Rezoning Transportation Analysis

Petition Number: #2022-099

Date	Description
11-28-22	First Review (IW)

**RZ-1**

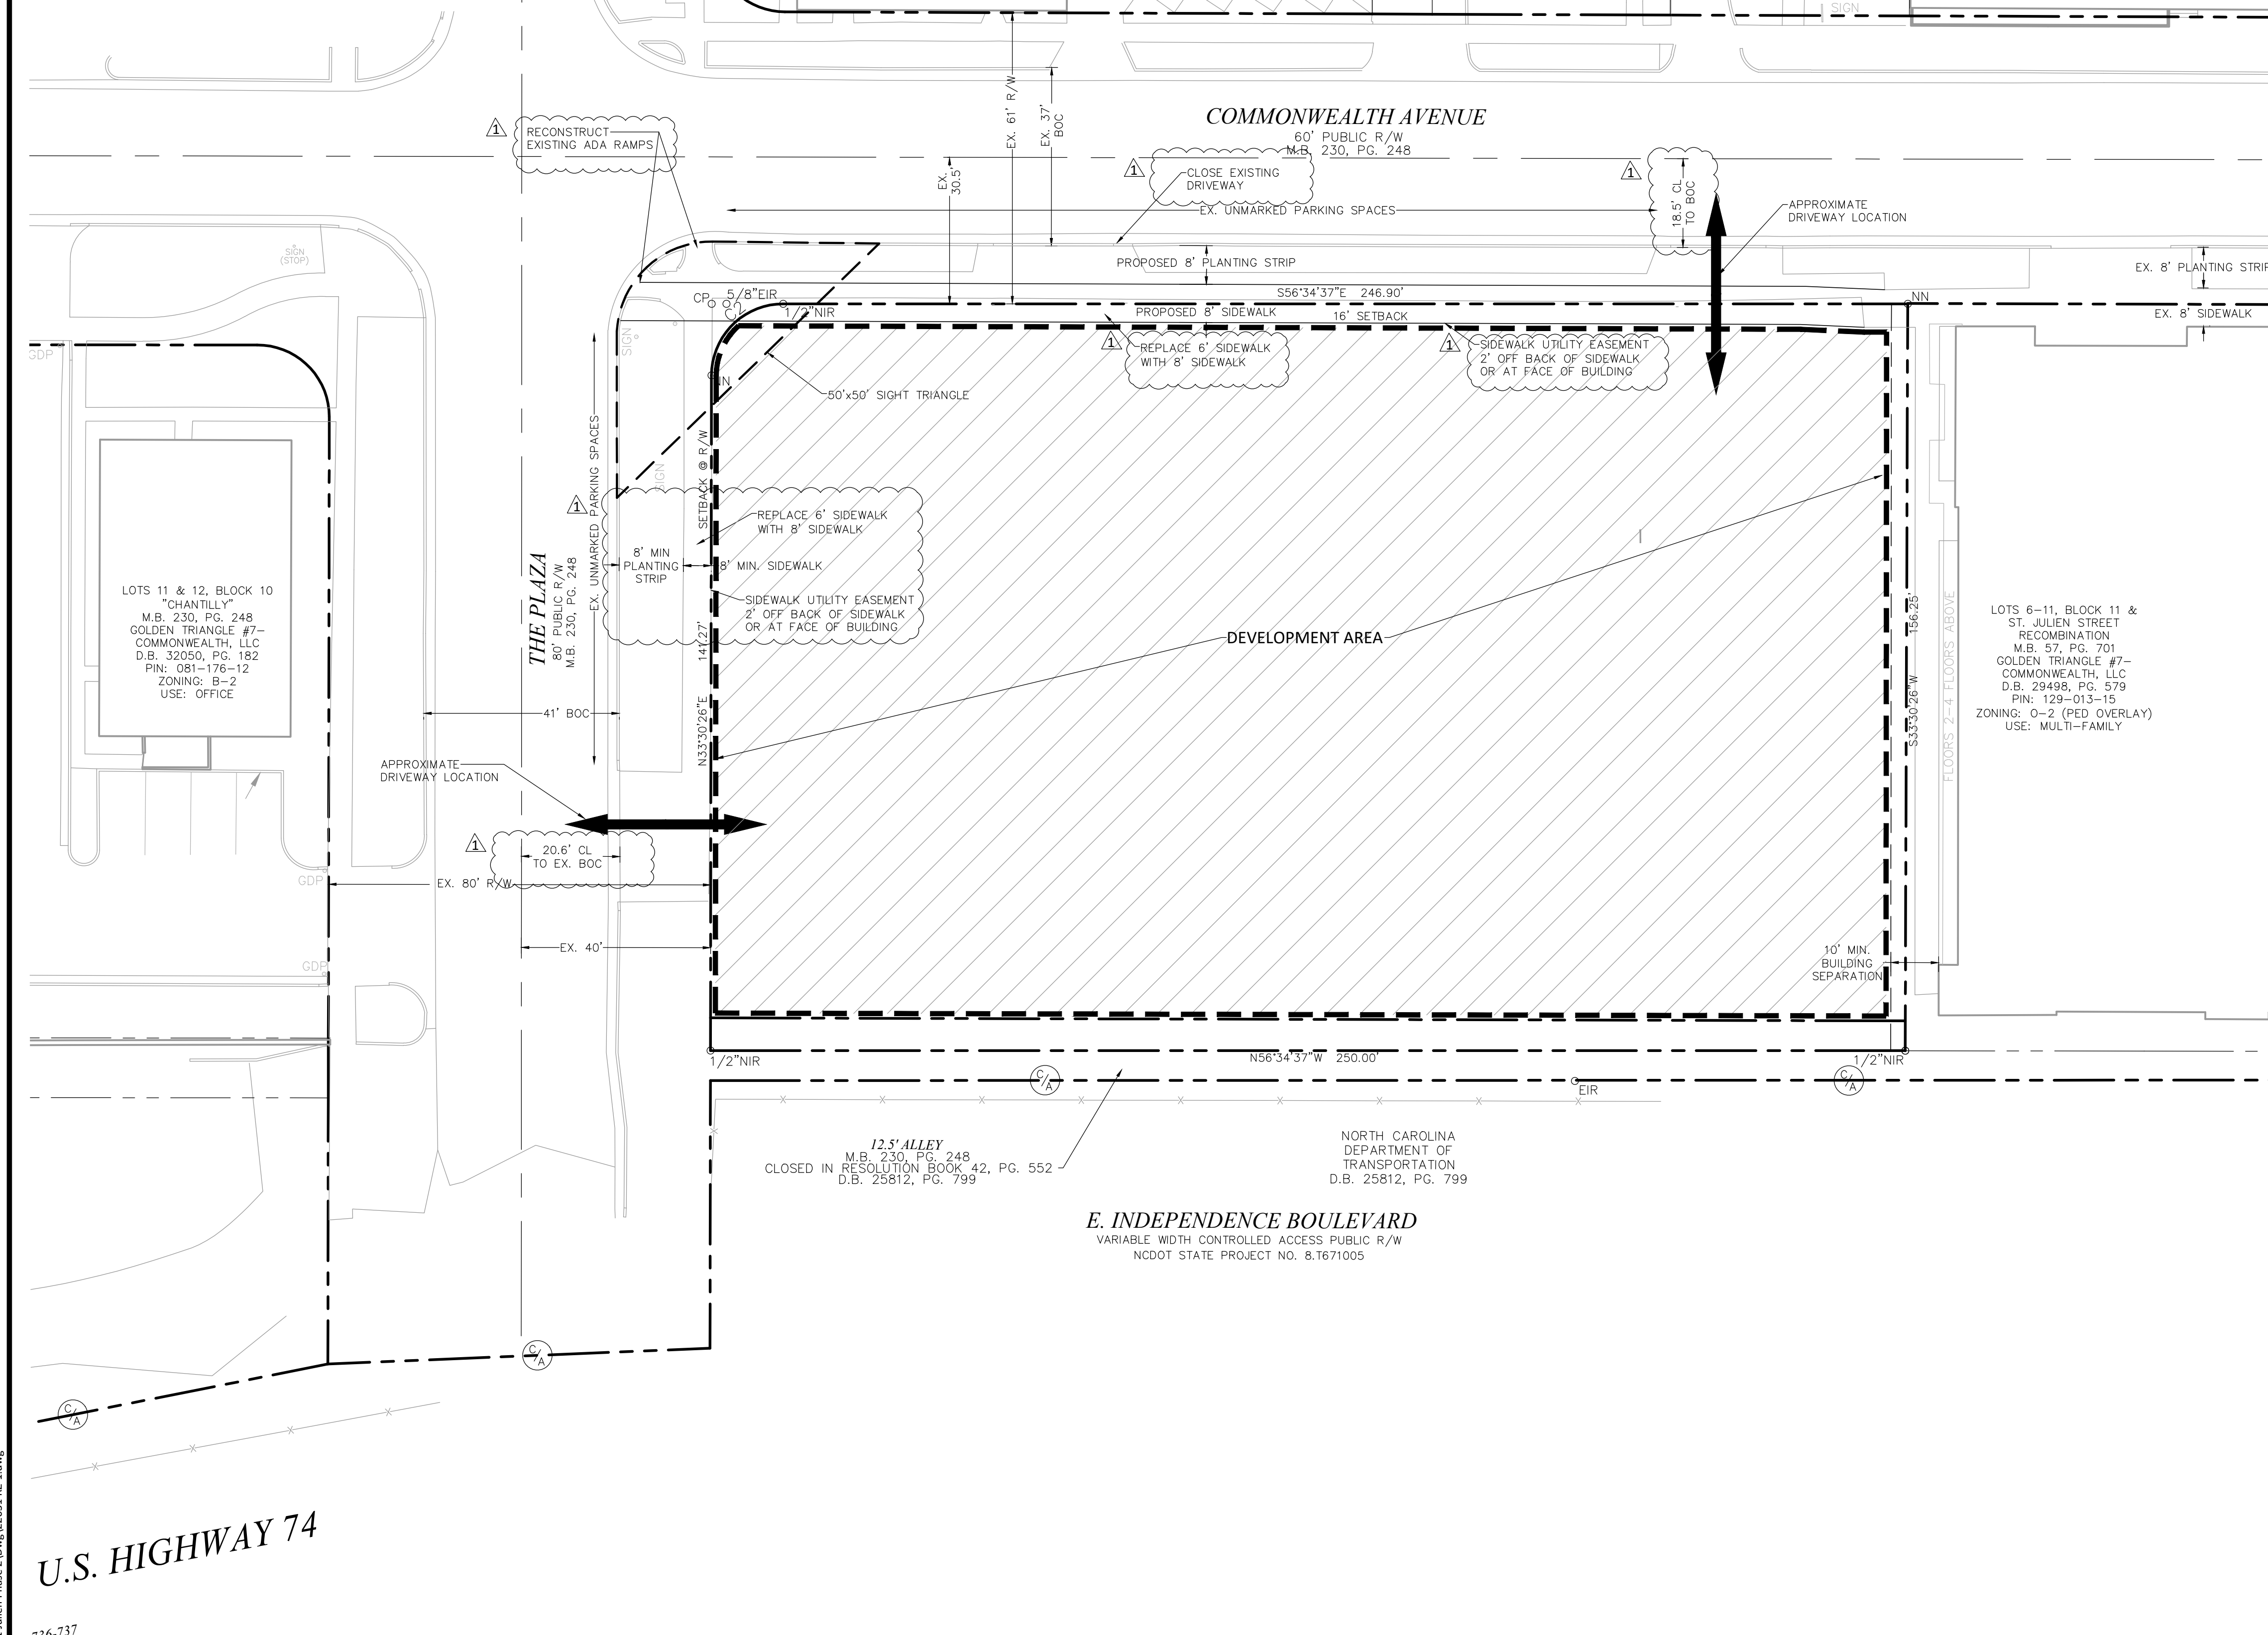
1. **Curblines:** The proposed zoning district has a setback measured from back of the existing or proposed future curblines.
 - a. **Commonwealth Avenue:** The future location of curb and gutter is in its existing location.
 - b. **The Plaza:** The future location of curb and gutter is in its existing location

Label and dimension the curb and gutter from the centerline for each road on the site plan.

4. Revise site plan and conditional note(s) to commit to dedicate 2 feet of sidewalk utility easement behind proposed sidewalk along Commonwealth Avenue and The Plaza. The site plan shall label and dimension sidewalk utility easement.

5. Revise site plan and conditional note(s) to specify what portion of the sidewalk along The Plaza will be proposed vs existing.

6. Revise site plan and conditional note(s) to show existing western driveway to be removed and curb and gutter to be replaced driveway on Commonwealth Avenue.

7. CDOT is requesting that the petitioner revise the site plan and conditional notes to commit to updating the ADA ramps at corner of The Plaza and Commonwealth Avenue.
8. A site plan note(s) specifying dedication and fee simple conveyance of all rights-of-way to the City before the site's first building certificate of occupancy is issued as needed. CDOT requests rights-of-way set at 2' behind back of sidewalk where feasible.
9. A site plan note specifying that all transportation improvements will be approved and constructed before the site's first building certificate of occupancy is issued as needed. The petitioner may phase transportation improvements if said improvements and phasing are explicitly described in site plan notes.
